SSD-9237 – PROPOSED MODIFICATION OF YARRABEE SOLAR PROJECT, BACK MORUNDAH ROAD, MORUNGAH.

I refer to your correspondence regarding the subject modified application which was referred to Transport for NSW for assessment and comment.

Transport for NSW has reviewed the documentation relating to the proposed modification for the Yarrabee Solar Farm prepared by SLR Consulting dated November 2019. From the information provided it is understood that the proposal is substantially the same project with the main alterations to the original proposal being;

Figure B.10 Existing and SIDRA Assessed Intersection Layouts

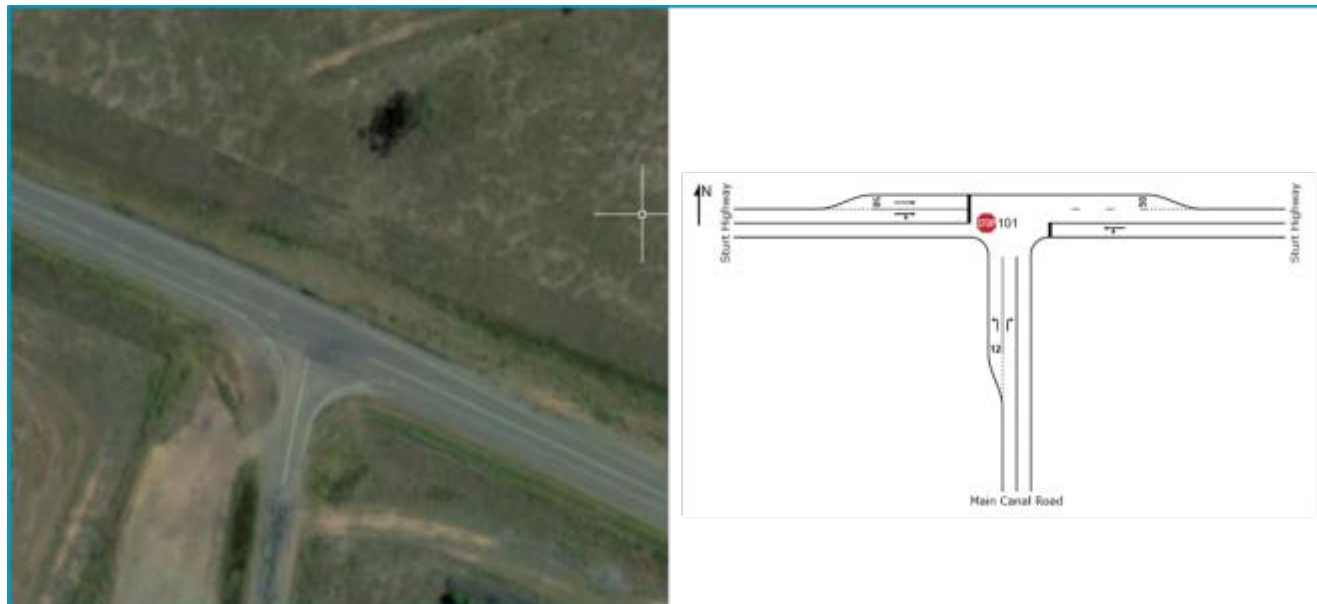
It is noted that construction related traffic is still proposed to use Main Canal Road from its intersection with the Sturt Highway. Schedule 3 Condition 3 (e) includes the upgrade of the intersection but Schedule 3 Condition 3 (f) removes the need to upgrade Main Canal Road to allow two-way construction traffic from its intersection with the Sturt Highway to Old Morundah Road. Should this route be used for construction and/or operational related purposes the requirement to upgrade Main Canal Road to allow for two-way movement from the Sturt Highway should remain.
